JEMALONG MUNDAMIA PROJECT

**RESPONSES to AGENCY COMMENTS on MUNDAMIA FLORA & FAUNA ASSESSMENT REPORT (SLR)
and UPDATED ASSESSMENT**

June 2015

PLAN SHOWING PROPOSED INTERIM BUSHFIRE MEASURES
FOR STAGE 1 ONLY
IN PROPOSED SUBDIVISION OF LOT 30 DP 1198692
(PREVIOUSLY LOT 3 DP 568613 & LOT 384 DP 755952)
AT MUNDAMIA GROWTH AREA
FOR JEMALONG MUNDAMIA PTY LTD

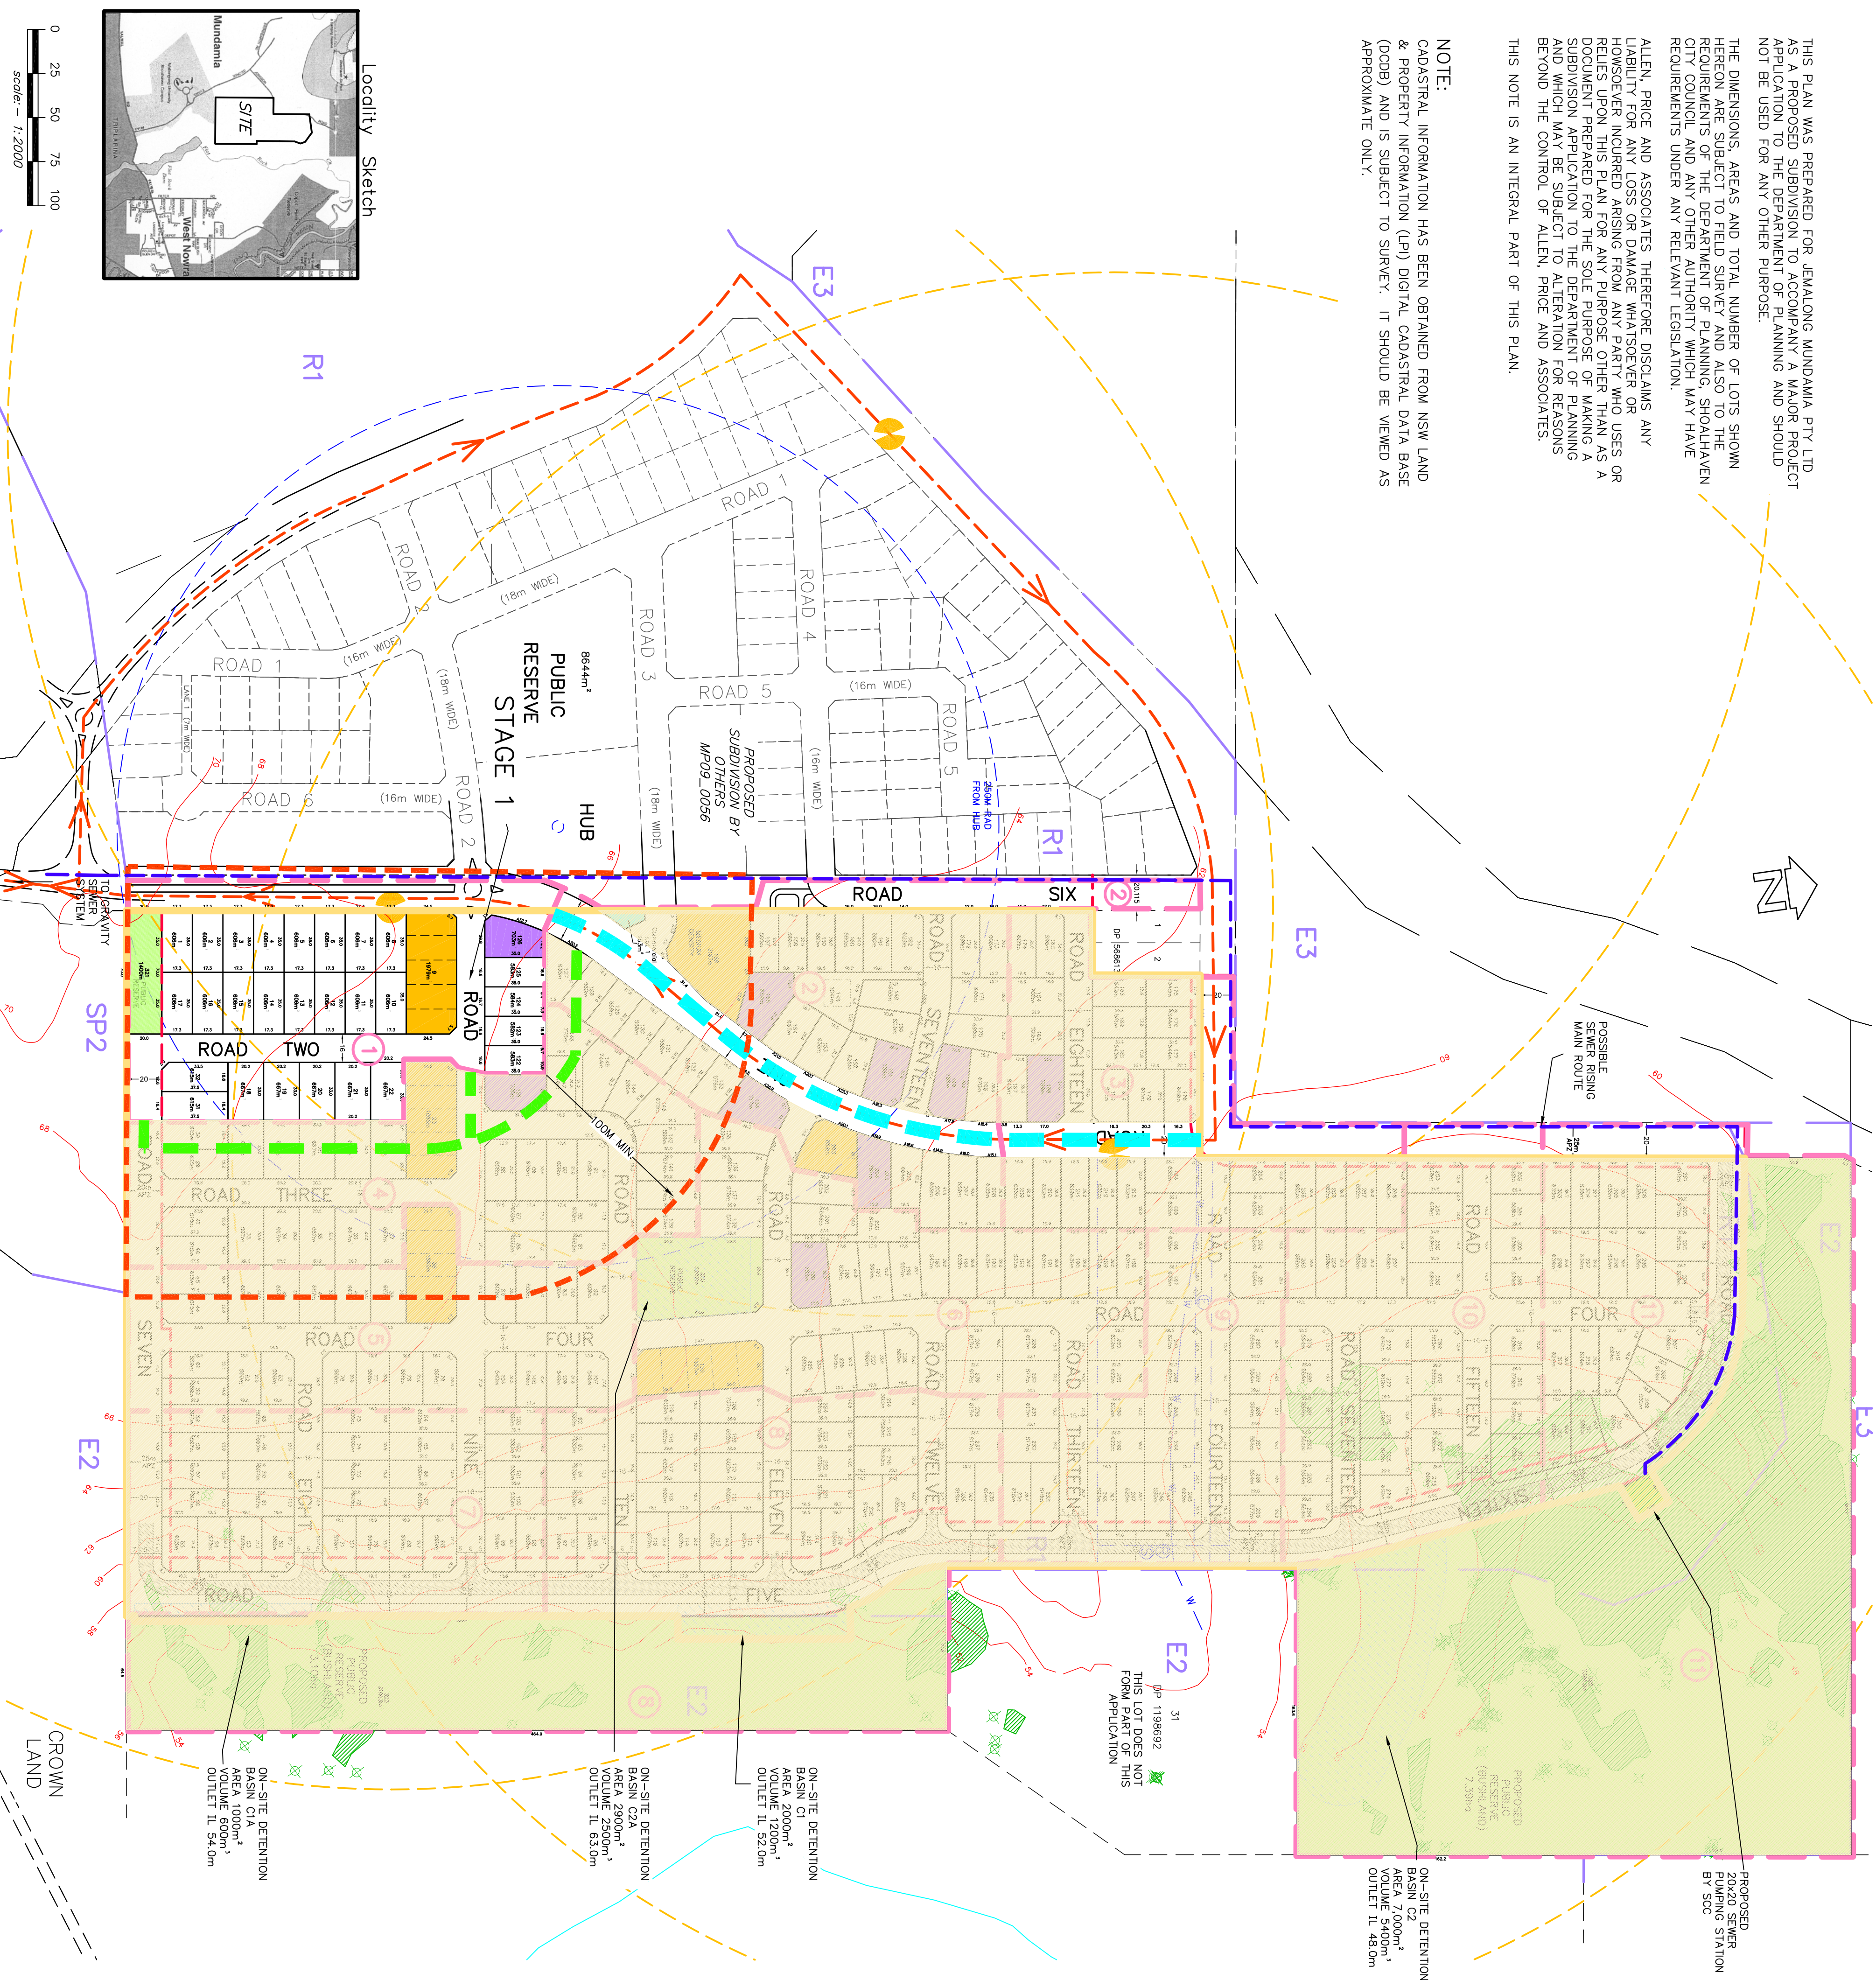
Agency	Comment	Response
OEH	Regardless of consistency or otherwise with the NBSP, the Asset Protection Zone (APZ) is considered as part of the development footprint and should not be located in land which is currently (and proposed to be) zoned as E2- Environmental Conservation.	The APZs have been removed from the Public Reserve. See Chapter 7.5 and Figure 8 of the SLR June 2015 <i>Report</i> .
	In addition, the area covered by the APZ should also be included in the calculation of areas of vegetation types to be impacted by the development (Table 2 Annexure 3) and consequently, should be considered in the development of an offset proposal (see below). The proposal to overlap APZs with the area proposed for environmental conservation on the eastern and northern boundaries is at odds with the statement in Section 4.5.2 of the EA that <i>"It should be noted that in relation to land zoned E2, these contain forested lands which are to be created as public reserves for dedication to sec to ensure their conservation into the future"</i>	The APZs are now entirely located within the development footprint.

Agency	Comment	Response
OEH	1.2 Vegetation Clearance and Offset	
	<p>As stated in section 13.11 of the EA the proposed offset for the development is currently 9.49 ha. This will encompass the Public Reserve proposed in the NE corner of the site and a strip along the eastern boundary. There is no indication in the EA whether or not this constitutes a suitable offset such as those reached using Government endorsed tools (Biobanking Assessment Methodology, PVP calculator). The initial appraisal of the offset by OEH suggests it does not appear to be sufficient for the loss of habitat and impact on threatened species at the site as the ratio of clearing is close to 1:1. OEH recommends the use of the Biobanking Assessment Methodology, or the PVP calculator to determine the appropriate level of offsetting for this vegetation type and threatened species habitat.</p>	<p>The <i>BioBanking Methodology</i> is not being used because:</p> <ol style="list-style-type: none"> 1 it is a voluntary process; and 2 it creates unreasonable offset ratios (of approximately 10:1) for development activities. <p>Furthermore, offsets were dealt with by the <i>Nowra-Bomaderry Structure Plan</i> and subsequent zoning of the subject site (see Chapter 8.3 of the SLR June 2015 <i>Report</i>). Other offsets include the rehabilitation and dedication of the Public Reserves to Council.</p>

<p>In addition approximately a further 2 ha of the conservation zone is proposed to be modified for the establishment of the APZ as per the guidelines in Planning for Bush Fire Protection (RFS 2006). Section 4.1.3 of the aforementioned document states that:</p> <p>The APZ is considered be part of the development footprint as its establishment and management requires removal or modification of the ecological integrity of remaining vegetation that greatly alters the structure and integrity of the vegetation. As such it is not consistent with the principle of improve or maintain biodiversity values and cannot be considered as part of the offset.</p>	<p>The APZs are now entirely located within the development footprint.</p> <p>The APZs are now entirely located within the development footprint.</p>
	<p>To be considered as a valid offset, the proposed offset area should be secured in perpetuity by an approved mechanism that is defined prior to construction. Currently the EA does not fully describe the mechanism for the conservation of the site in perpetuity or the nature of funding for management of the offset. OEH does not consider the current offset proposal satisfies the OEH principles for biodiversity offsetting. These principles can be found at the following link http://www.environment.nsw.gov.au/biocertification/offsets.htm</p>	<p>This issue will be the subject of negotiations between the proponent and Council - post development approval.</p> <p>The <i>Principles</i> for biodiversity offsetting have been addressed in the SLR June 2015 <i>Report</i> – see Chapter 8.3.3.</p> <p>Offsets were dealt with by the <i>Nowra-Bomaderry Structure Plan</i> and subsequent zoning of the subject site, and are addressed in Chapter 8 of the SLR June 2015 <i>Report</i>.</p>
